10th November 2020

Application No: EP/124/20/HH
Site Address: Little Dormers 23 Upper Drive East Preston BN16 1QN
Description of works: New bay and porch skirt roof to the front elevation, and roof linked detached double garage.

Objections to Planning Application: EP/124/20/HH - 23 Upper Drive, East Preston

Location Plan and Block Plan

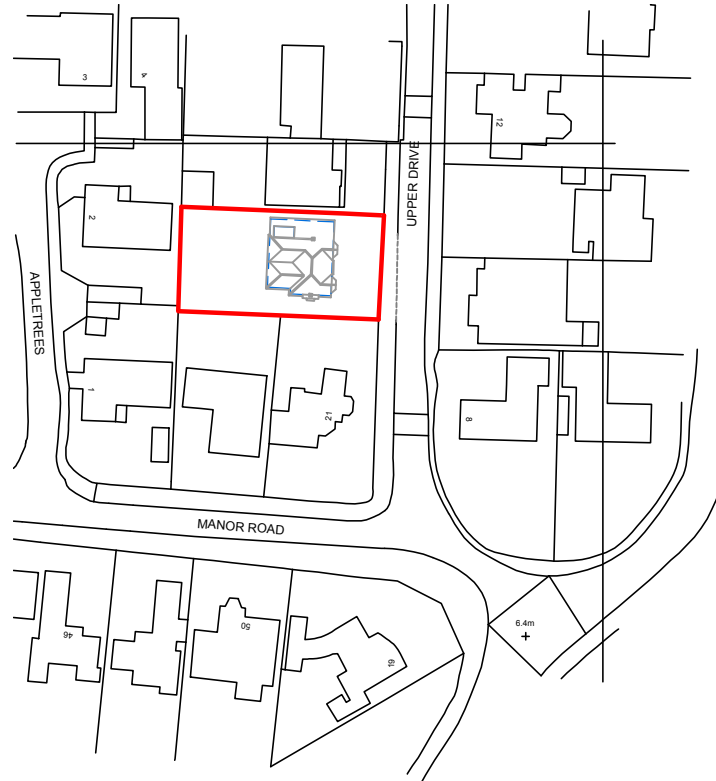
By it's position, the Garage completely contravenes the building lines of all the properties on the western side of Upper Drive, namely No's 21, 25, 27 and 29 and materially changes the consistent view of properties in Upper Drive.

By having to extend out to the road edge, the plot clearly is insufficient to accommodate a detached garage in that location.

The Garage extremity to the East (roadside) may contravene the properties Land Registry boundary, as the Angmering-on-Sea Estate Residents Association (AOSERA) own all estate verges. In the past the verge at No. 23 was replaced with tarmac, giving the appearance that it is part of the Road, however, it should not be built over.

Garage Plans and Elevations -
Proposed

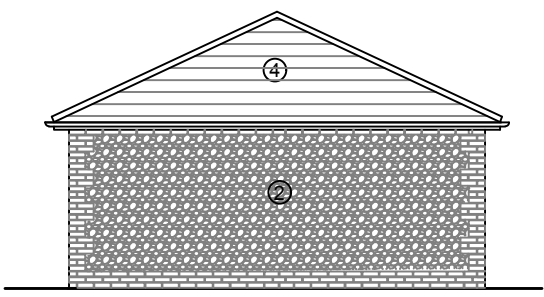
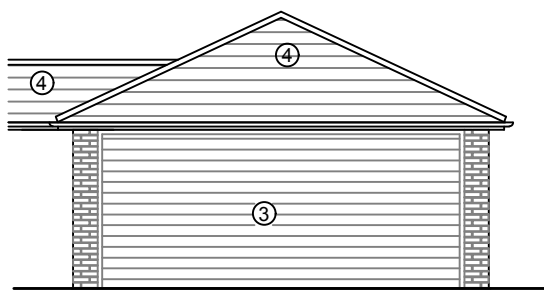
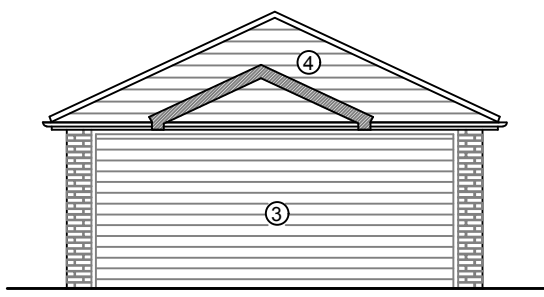
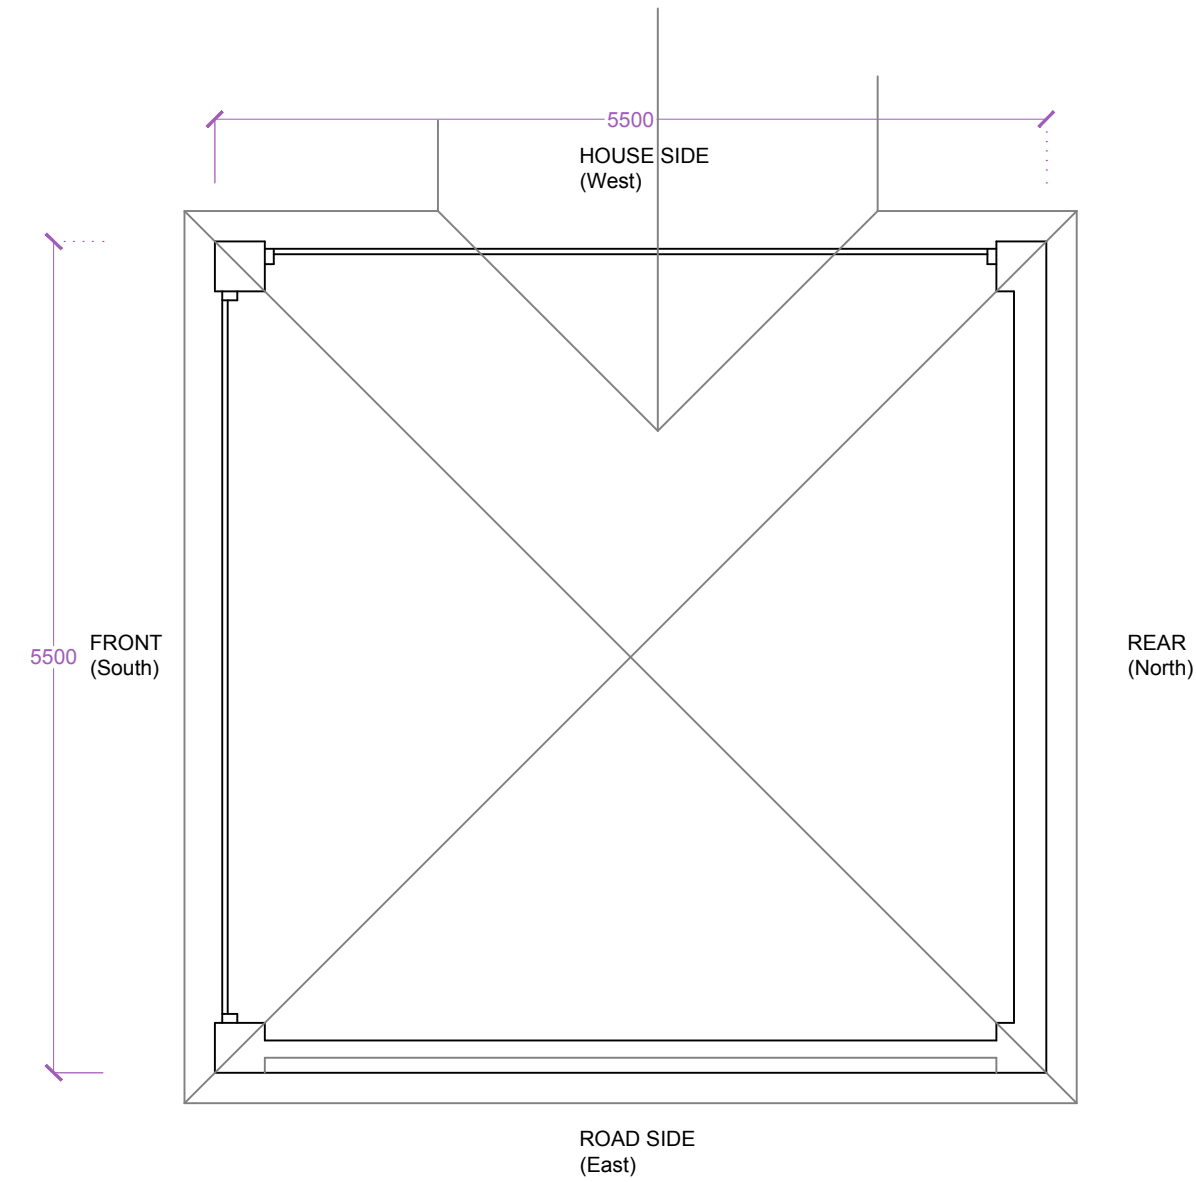
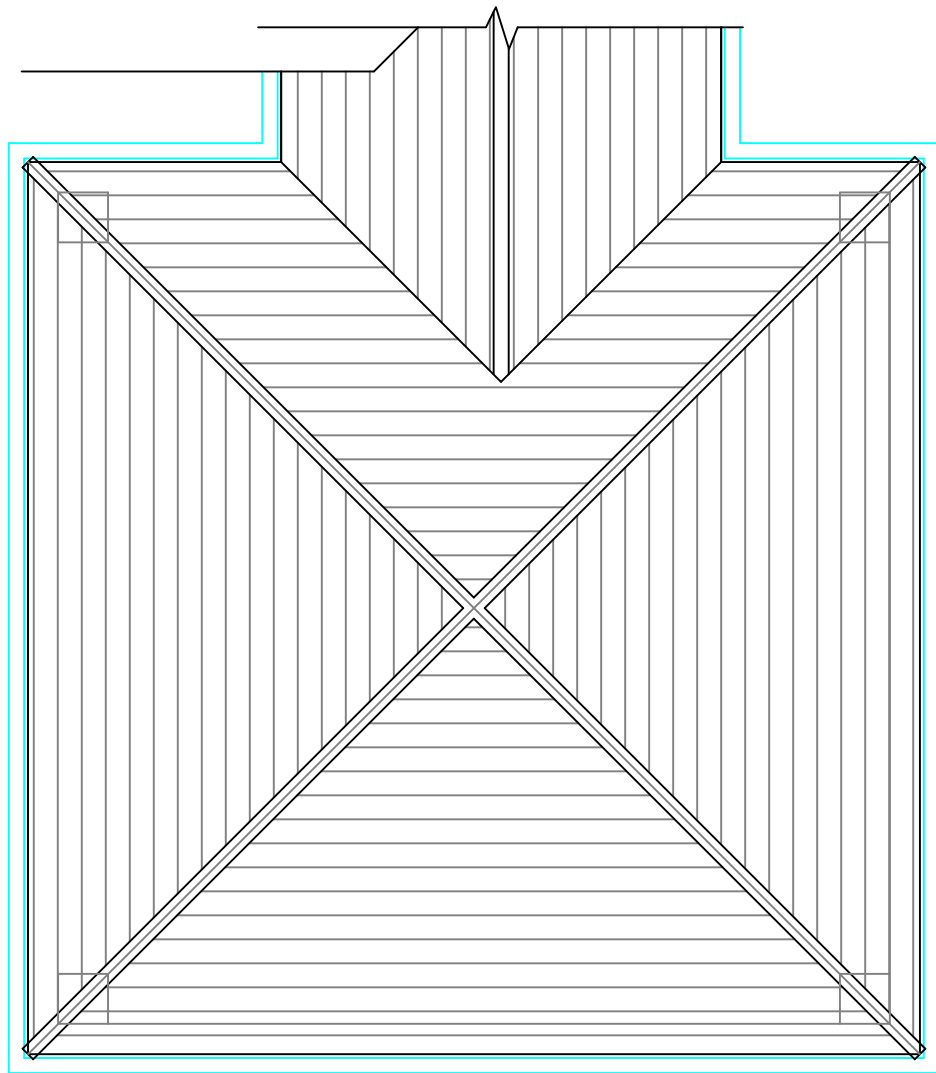
The Garage is unnecessarily large in both height and width.

Visual access to Upper Drive, re: oncoming traffic, from No. 25 particularly, will be seriously impaired by such an imposing structure.

The effect of reduced daylight to No. 25 by such a large structure should also be taken into consideration.

The proposed Garage is not adjoining the premises and as such it is a separate structure, therefore contravening the Estate Covenants. As allowed by the Covenants, there is already an existing garage attached to the property.
